Jeanie Bourke - Re: 23 Emerson Street - BP#2015-01540

From: Jeanie Bourke
To: Tracie Reed
Date: 9/24/2015 12:14 PM
Subject: Re: 23 Emerson Street - BP#2015-01540
CC: Craig Messinger; Keith Gautreau; Peter Valcourt
Attachments: T-1 - Title Sheet.pdf

Jeanie, Attached please find revised sheets for the 23 Emerson Street project addressing your review notes.

Basement & First Floor LS Plan
Project number 15-16
Date 06.23.15
Drawn by TJR
Checked by TJR
LS-1.1
Scale 1/4" = 1'-0"

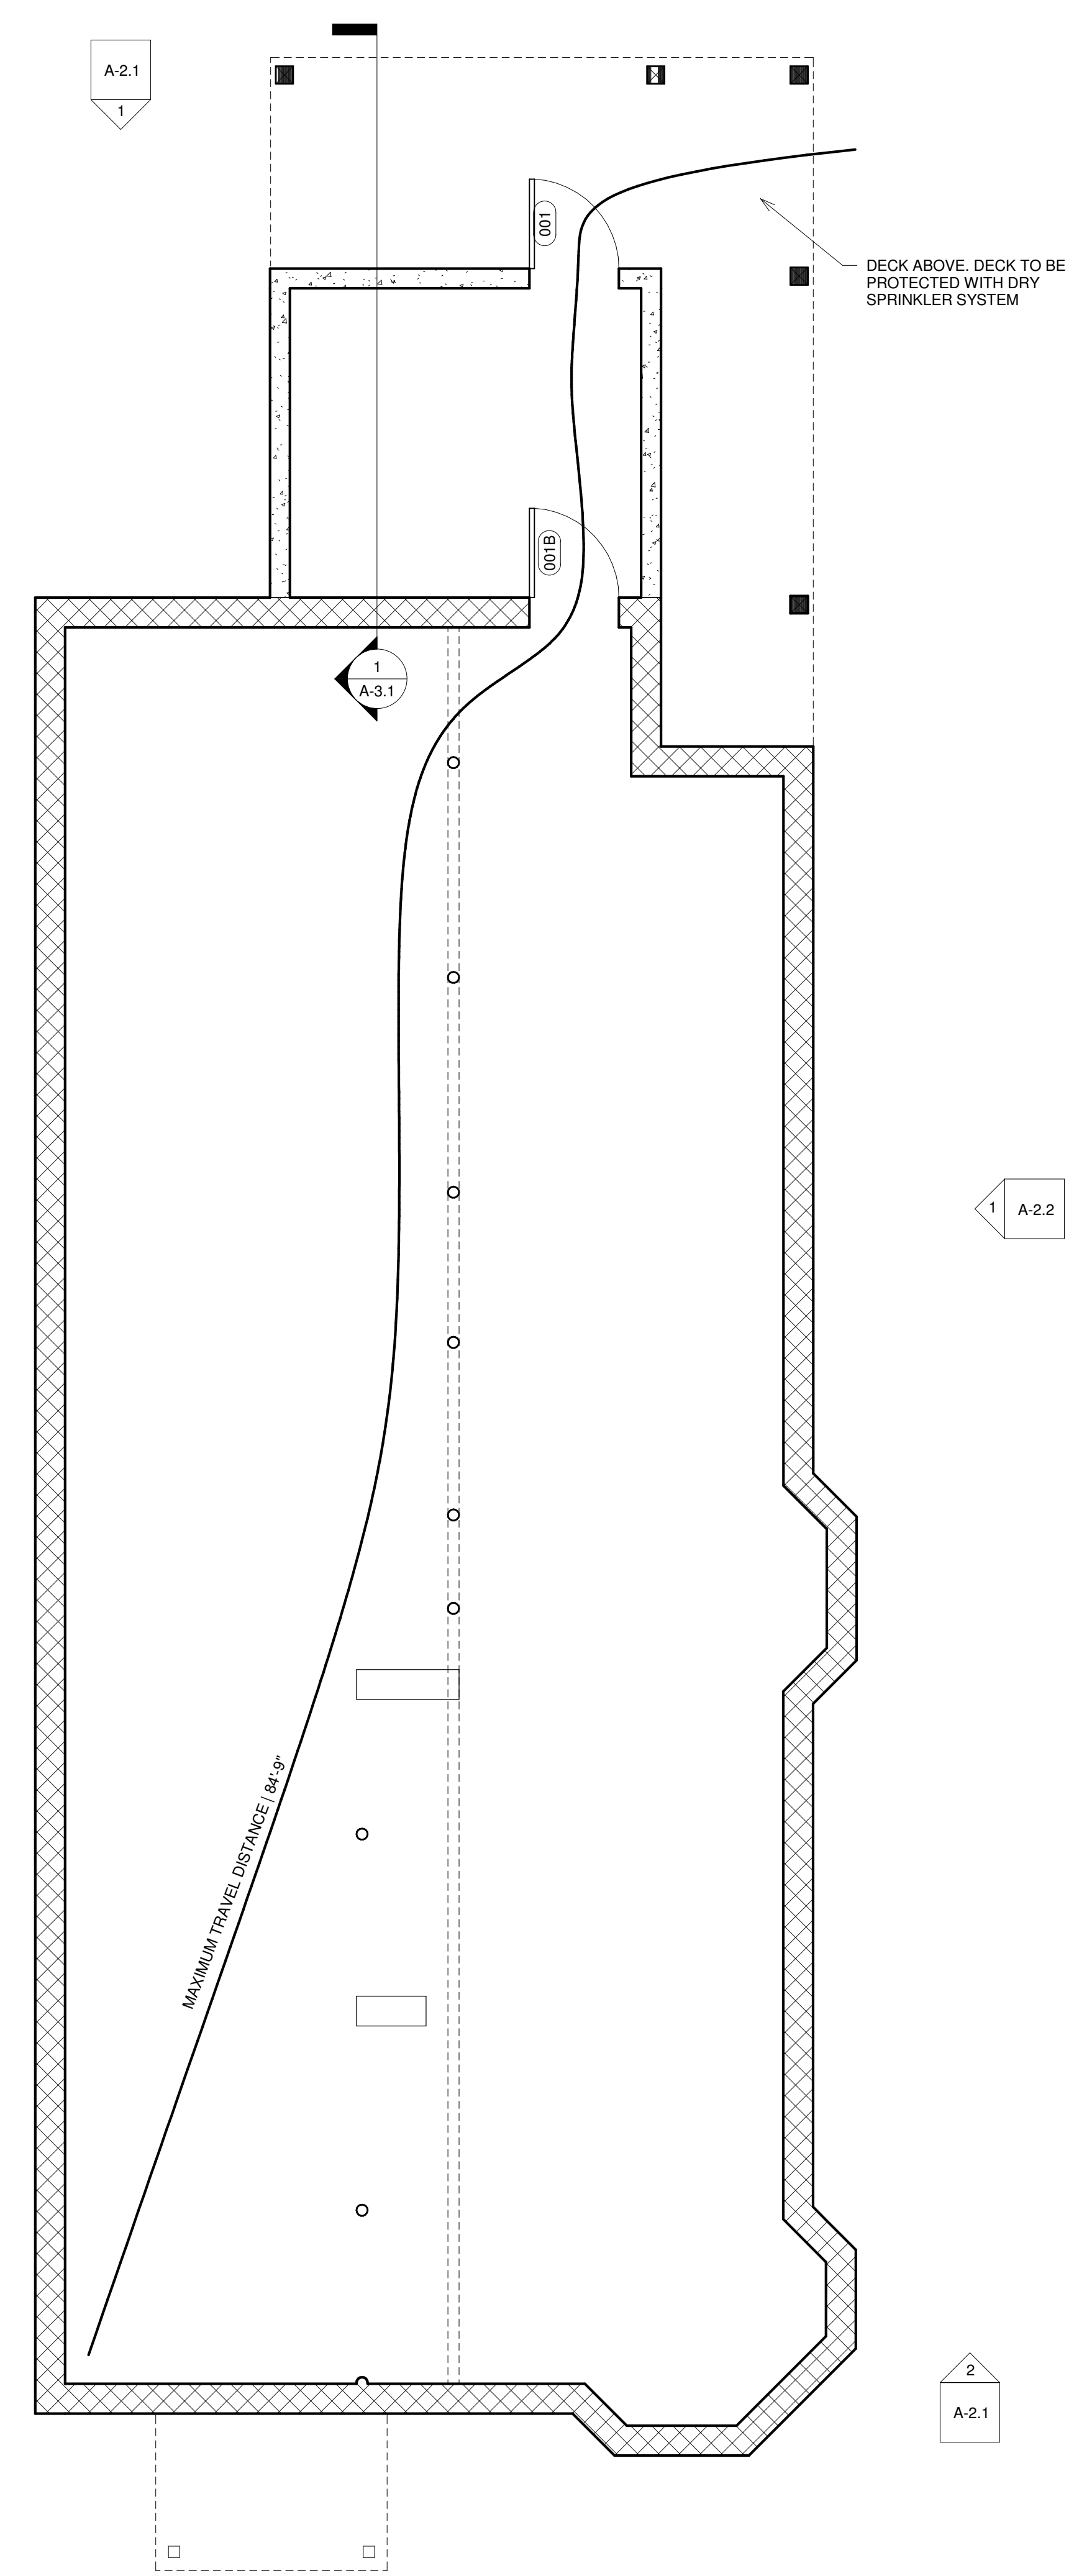
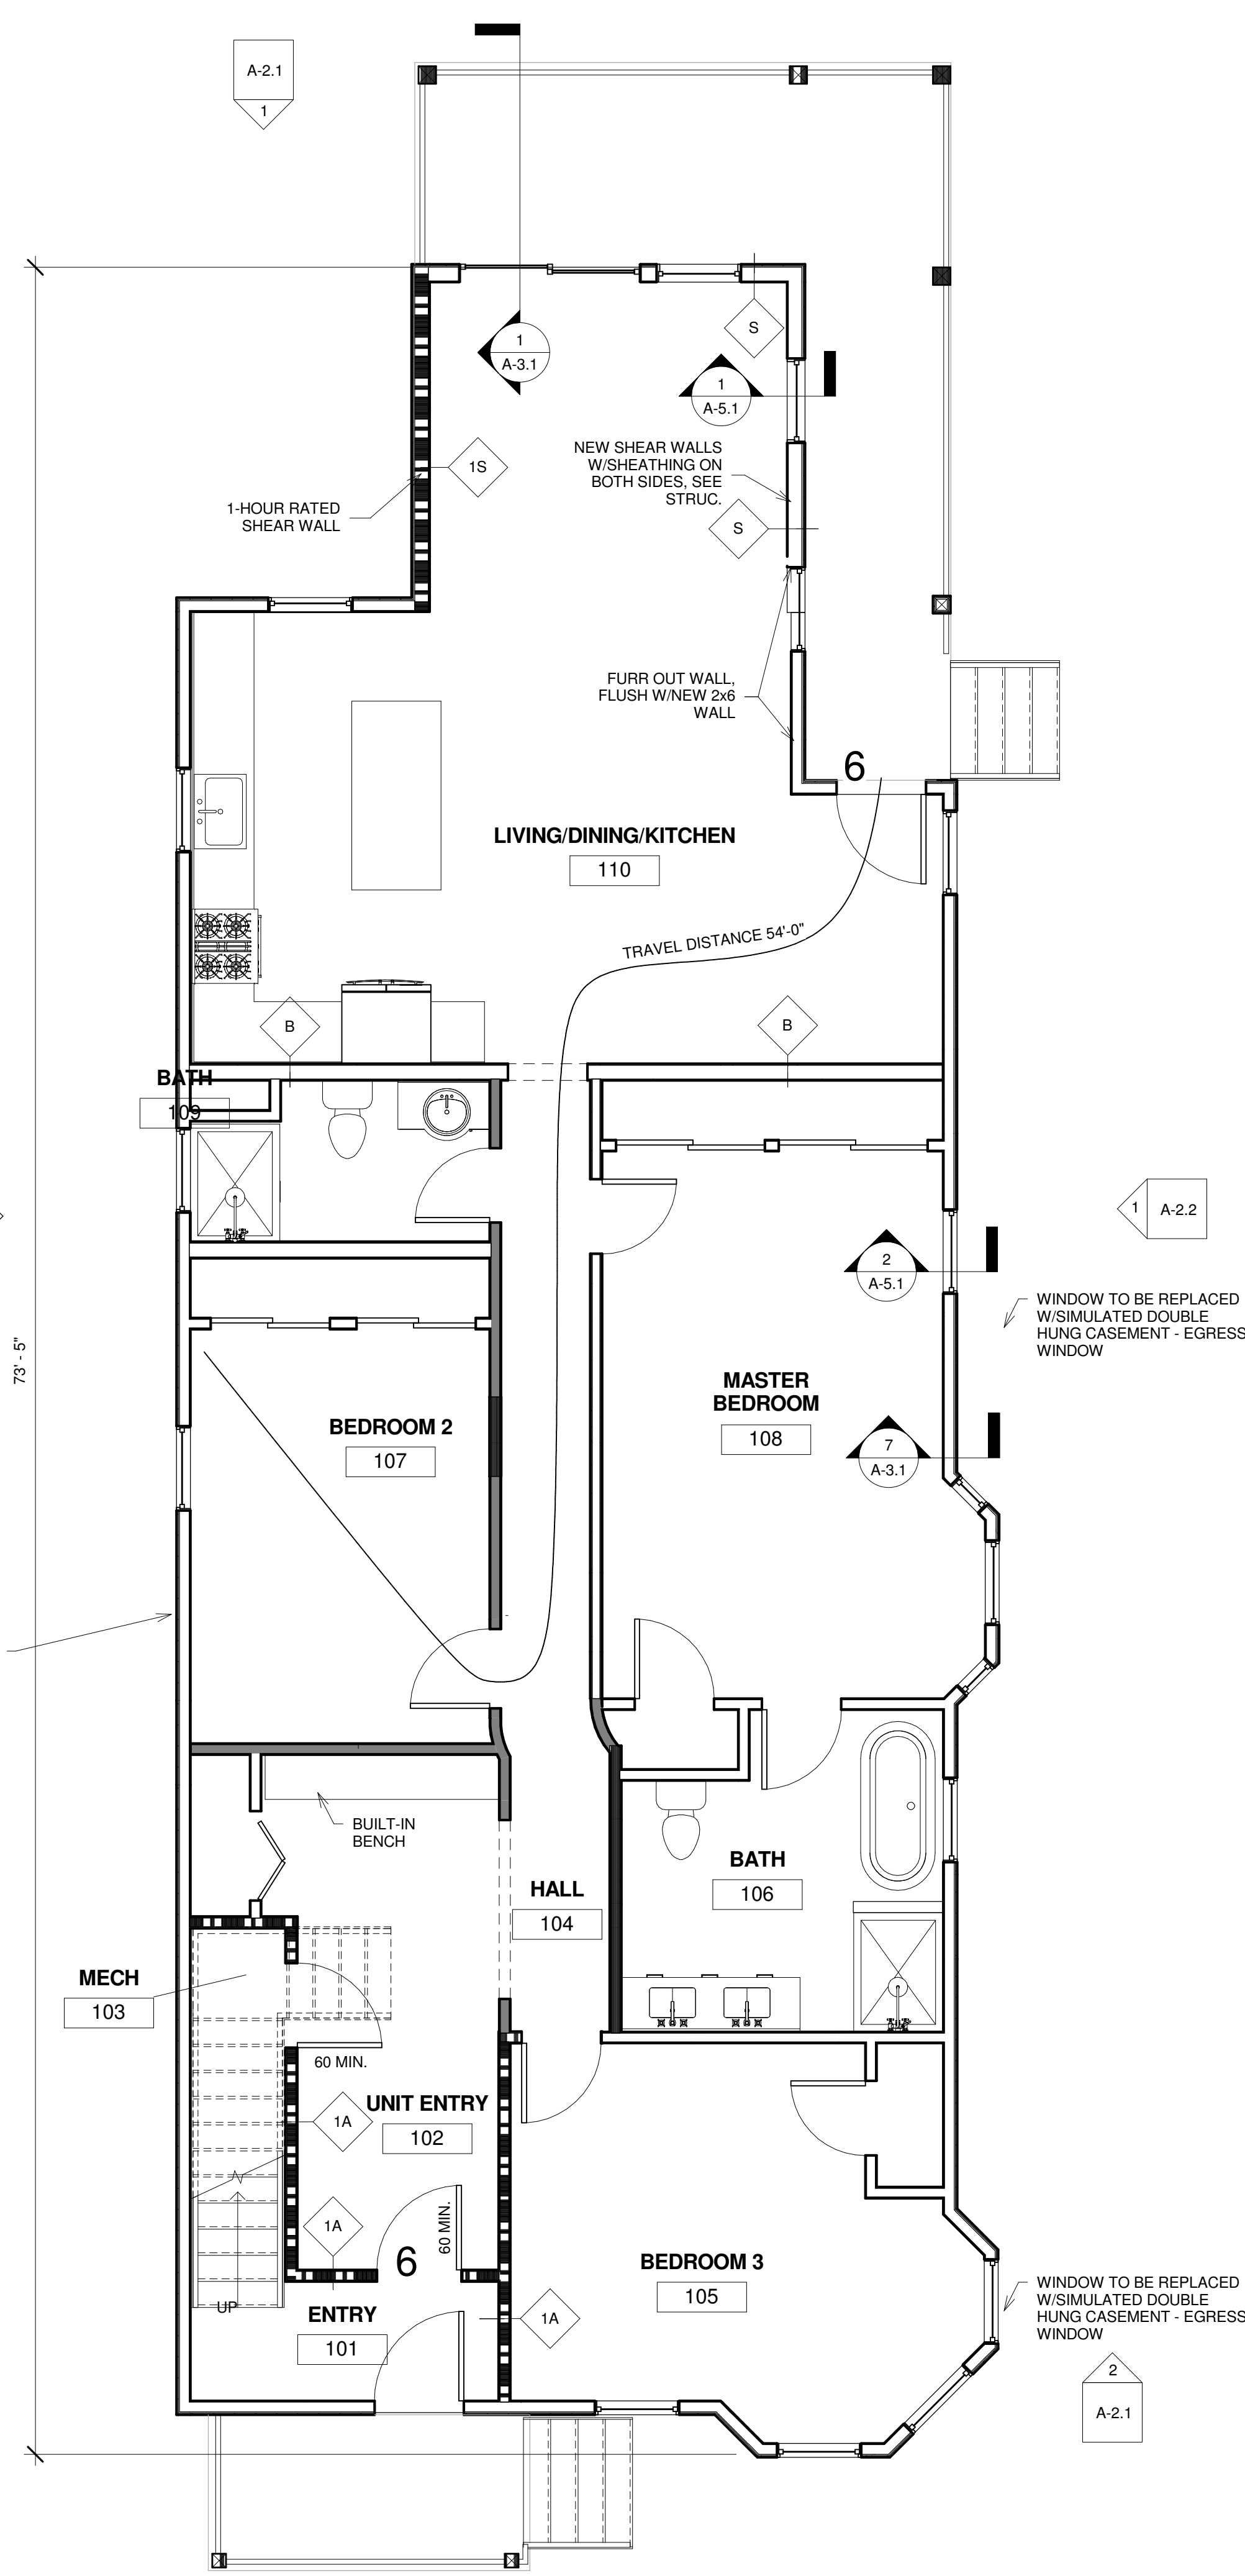
I question your reference to NFPA Table A.31.1, as the implication here is that this applies to buildings/stories with more than one exit. When an exit is removed, even if the building is sprinkled, there are thresholds to be met. The given TD of 66'-9" does not meet IBC requirements for a single exit on the 2nd and 3rd floors. A maximum of 50' is allowed to an exit, which includes travel within the dwelling and a corridor, if applicable.

Travel Distance | In regard to travel distance, the building commentary section of IBC 2009 1021.2 notes the intent of the travel distance regulation in allowing smaller buildings of limited size and configuration with access to a single-exit. Table 1021.2 allows for up to 4-dwelling units per floor to have a 50'-0" travel distance within the R-2 occupancy classification. In the 23 Emerson Street project there are only two units, one per floor, with single exits above grade. As noted, these units have a travel distance of approximately 66'-9". IBC would allow for up to four units per story, a much higher density. In this project the existing travel distance to the code-compliant front stair is over 50'-0" with the sprinklered balcony adding 5'-6" in travel distance. Note the existing building is not sprinklered, nor does it have a fire-rated corridor, or fire-rated doors.

This 66'-9" travel distance is within NFPA 101 2009's travel distance allowance of 75'-0" within an existing apartment protected by an automatic sprinkler system, per table A.31.1 Alternate Requirements for Existing Apartment Buildings According to Protection Provided.

While the building does not meet the 50'-0" travel distance threshold outlined in IBC 2009 table 1021.2 for a single-exit from a three-story, three-unit building, the fact that MUBEC defers to NFPA Life Safety 101 travel distance tables in section 7.6 suggests that a building falling

Title Sheet

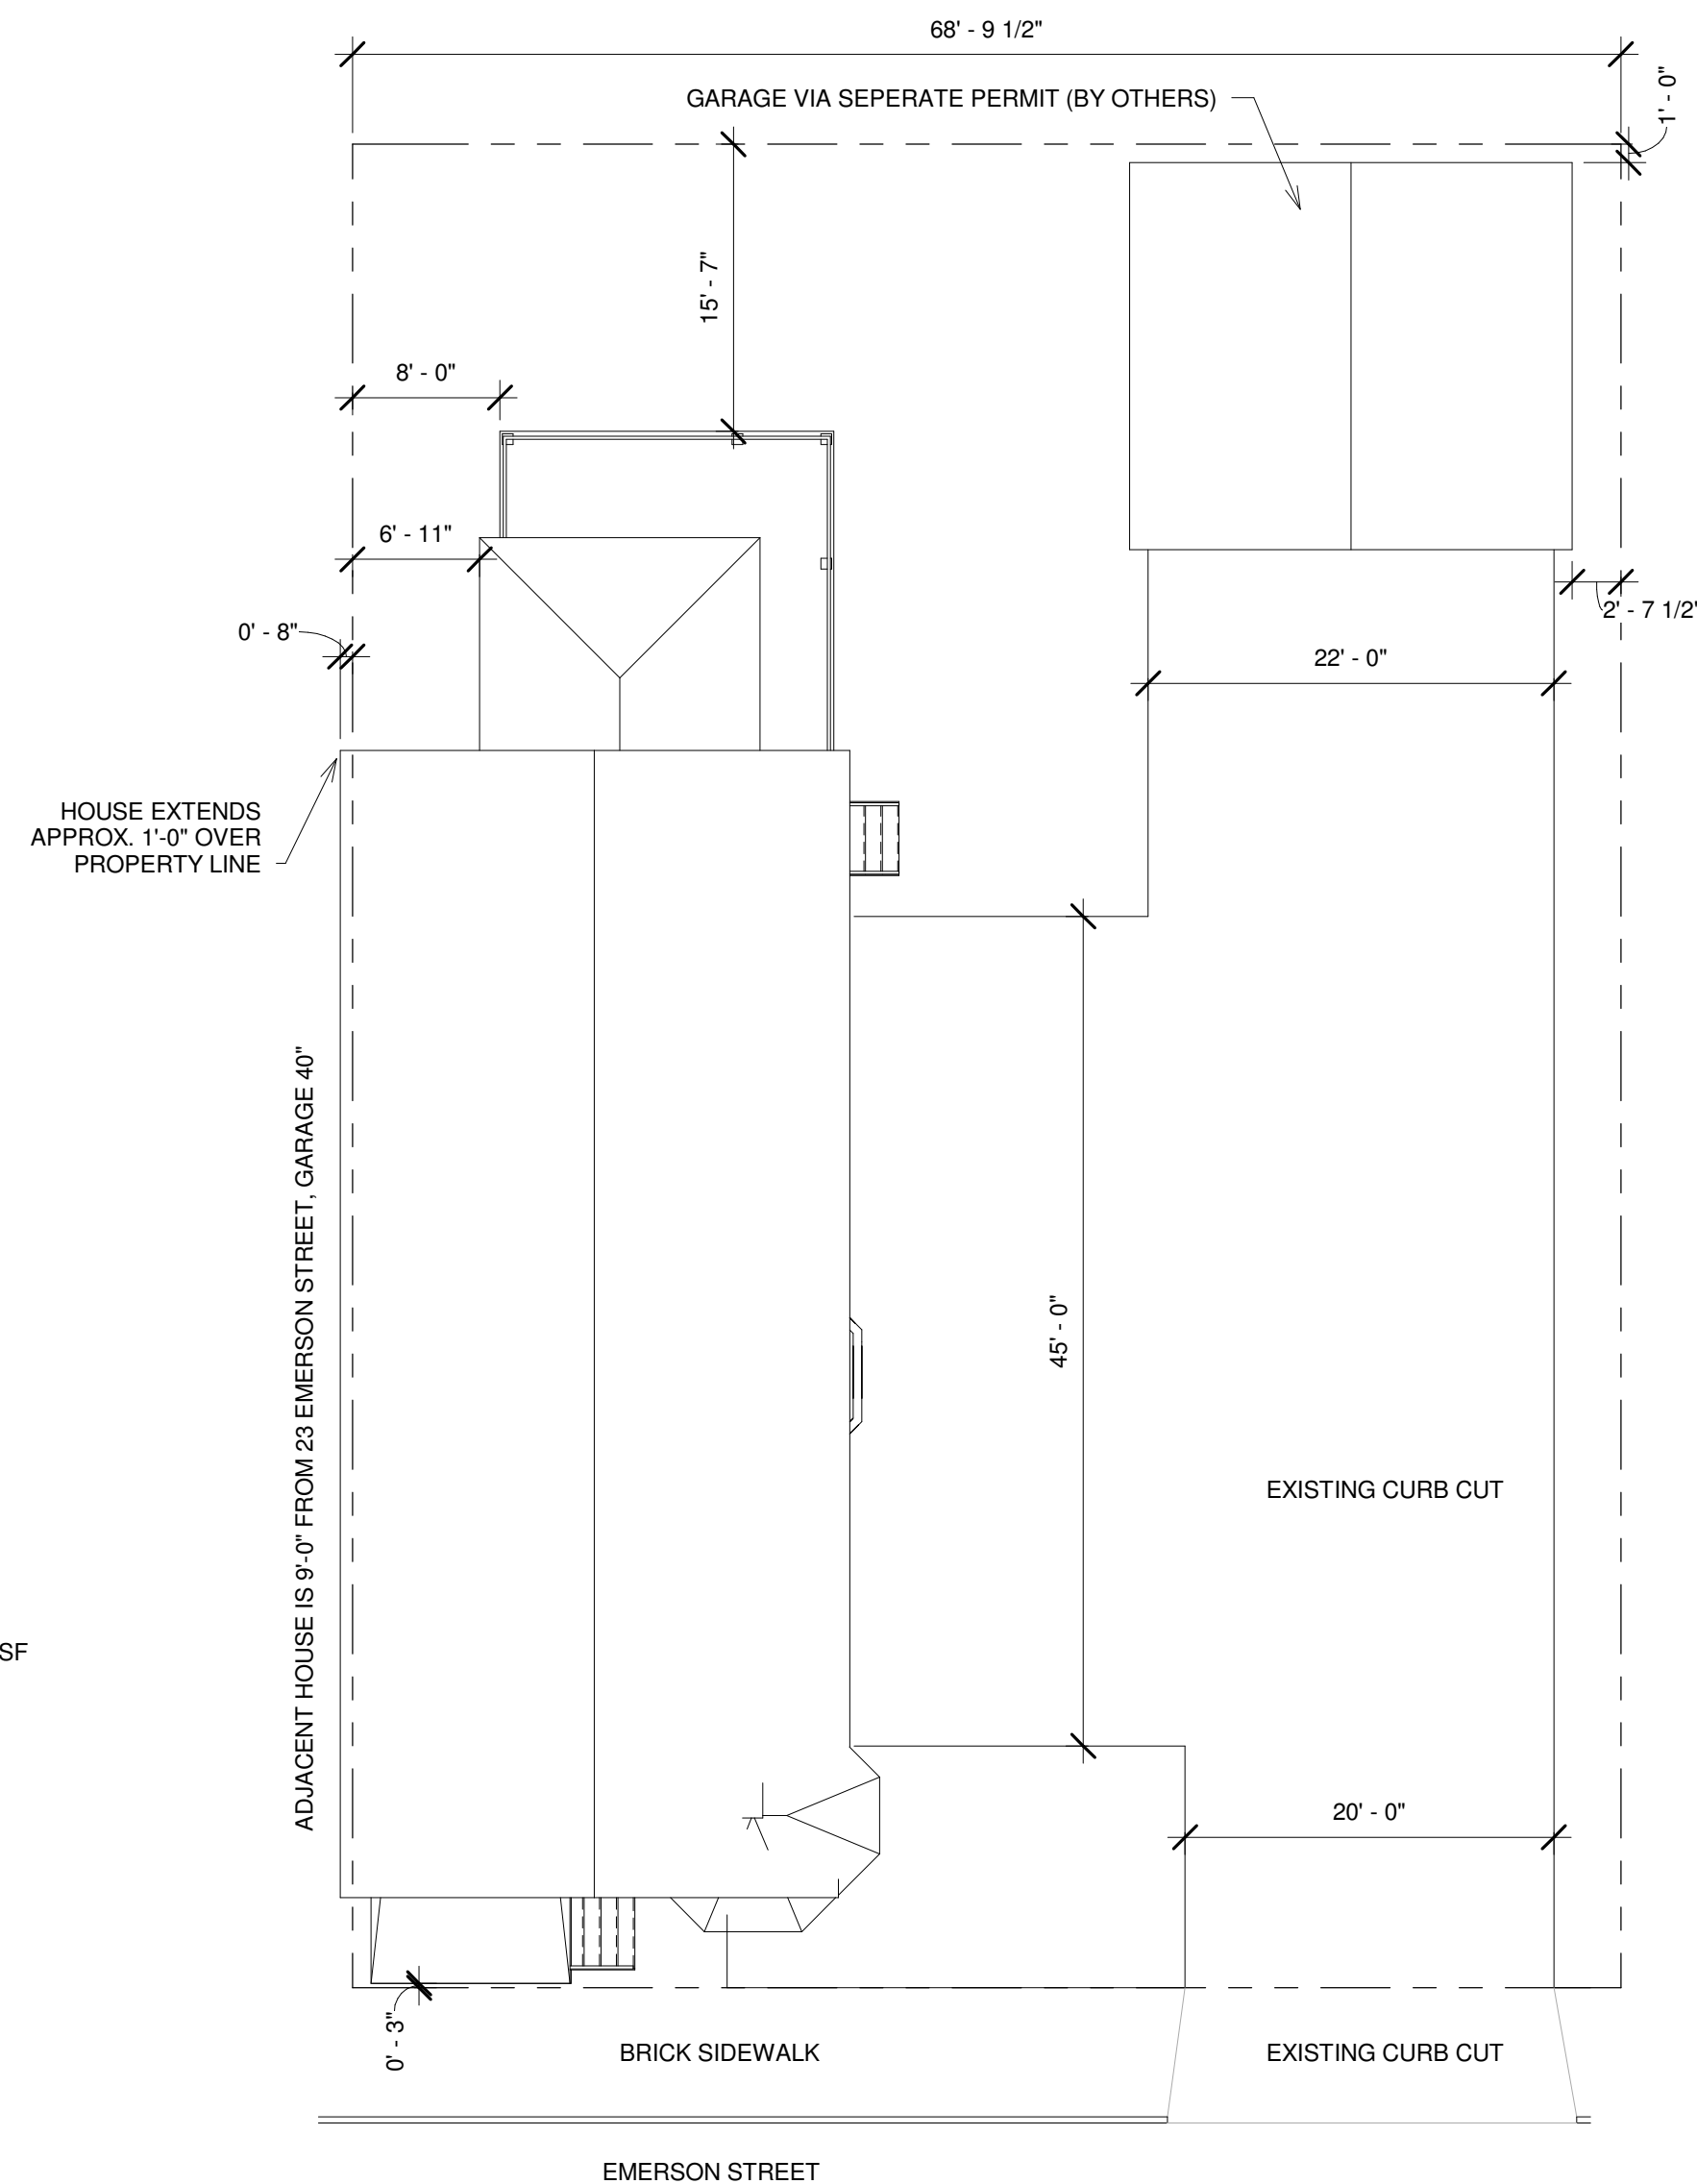
To comply with the I-code you will need to reference the IEBC as I have noted on the attached plan. Please revise and submit, I think this is the only outstanding item prior to approving the permit.
